KIRKLEES METROPOLITAN COUNCIL INVESTMENT & REGENERATION SERVICE

DELEGATED DECISION TO DETERMINE APPLICATIONS FOR NON-MATERIAL AMENDMENTS

Reference No: **2021/NM/92735/E**

Description: Non material amendment to previous permission 2018/93963 for erection of two storey rear extension

DRAWING NO
3151/3

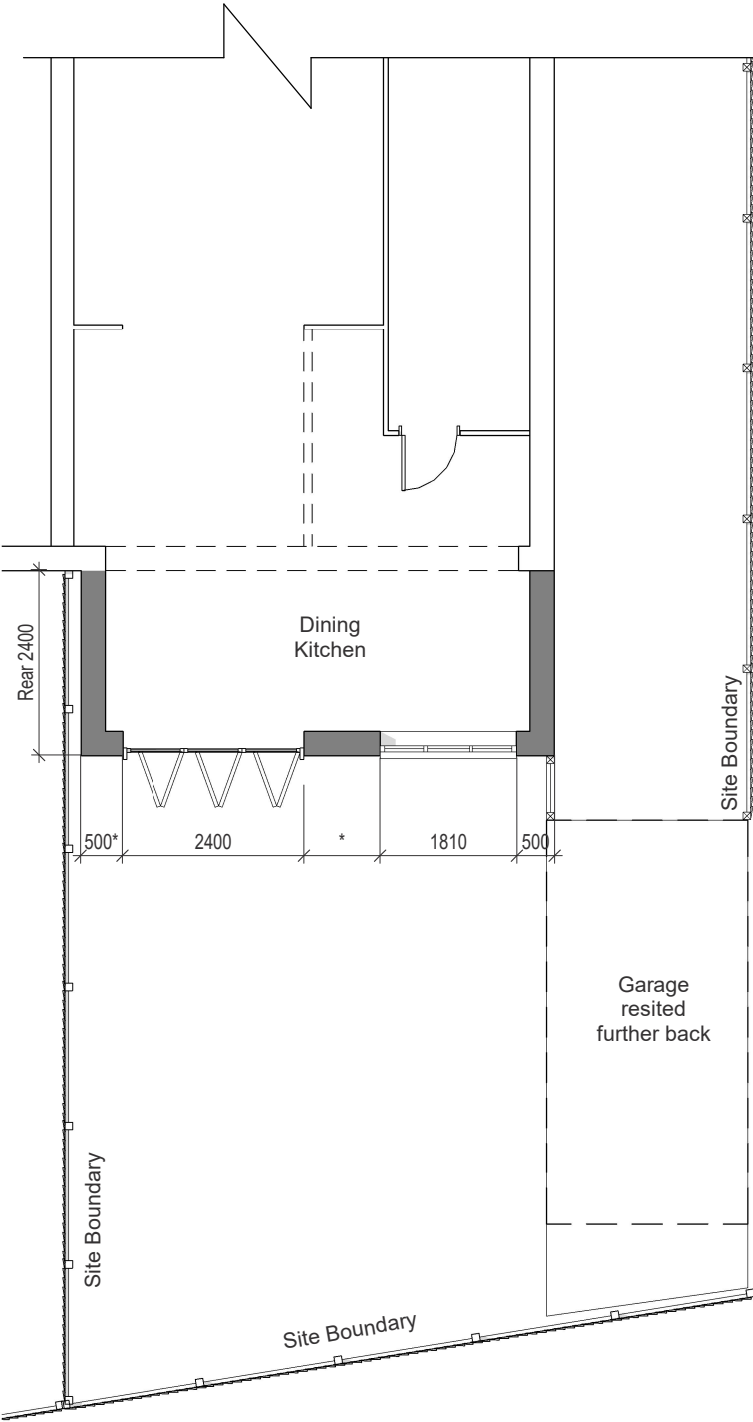
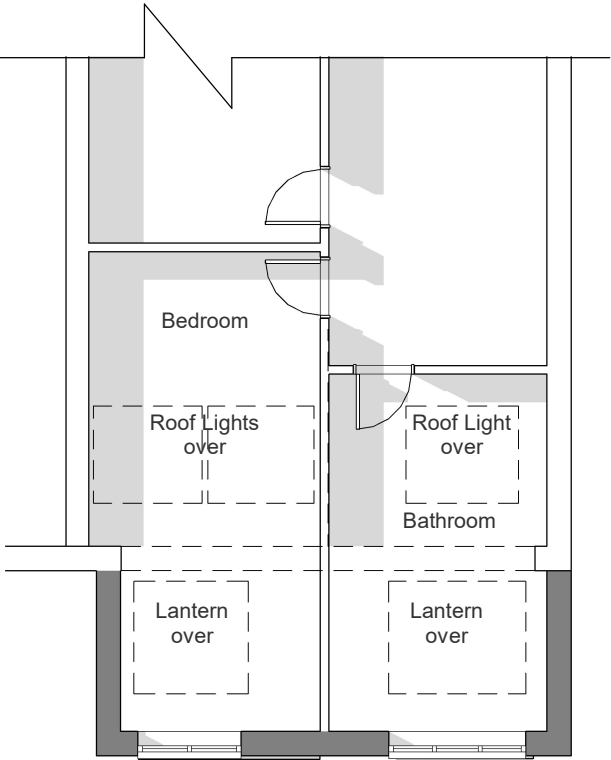
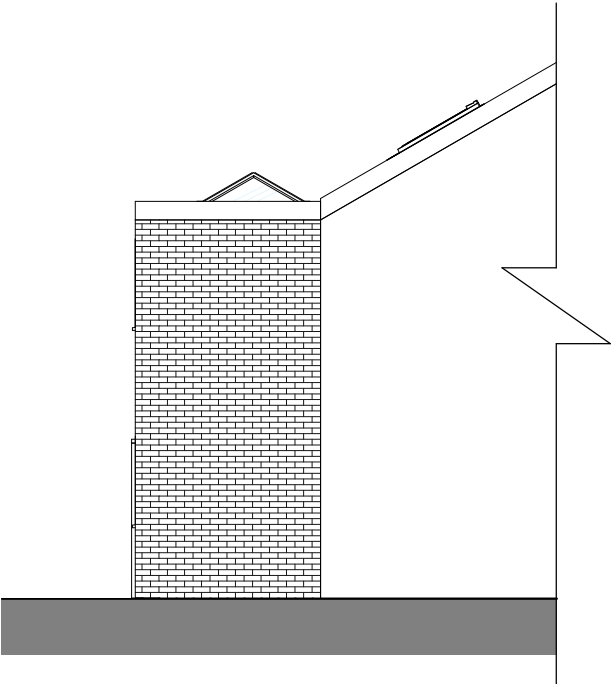
No, whilst the footprint appears to be the same, the roof design is different replacing a dual pitched roof and gable end with flat roof at eaves level and two large lantern roof lights. There would also be three velux windows on rear facing roof plane. It is considered that these changes significantly alter the appearance of the originally approved scheme.

Yes, the proposed change could result in a detrimental impact on visual amenity of the area.

Whilst there would be less massing at roof level it may have an impact in terms of visual amenity.

The proposed amendment would now be assessed in terms of policy LP24 of the Local plan and guidance given in the Kirklees House extensions Supplementary Planning Guidance. The amendment would be contrary to this policy and guidance

It would contravene condition 2, in that the proposal would not be carried out in complete accordance with the plans and specification listed in the decision notice. Condition 3, in that the roofing materials would not match those used in the construction of the existing building.

It is considered to fall outside the scope of being a non-material amendment as in officers' opinion the proposal would significantly alter the appearance of the approved two storey rear extension.
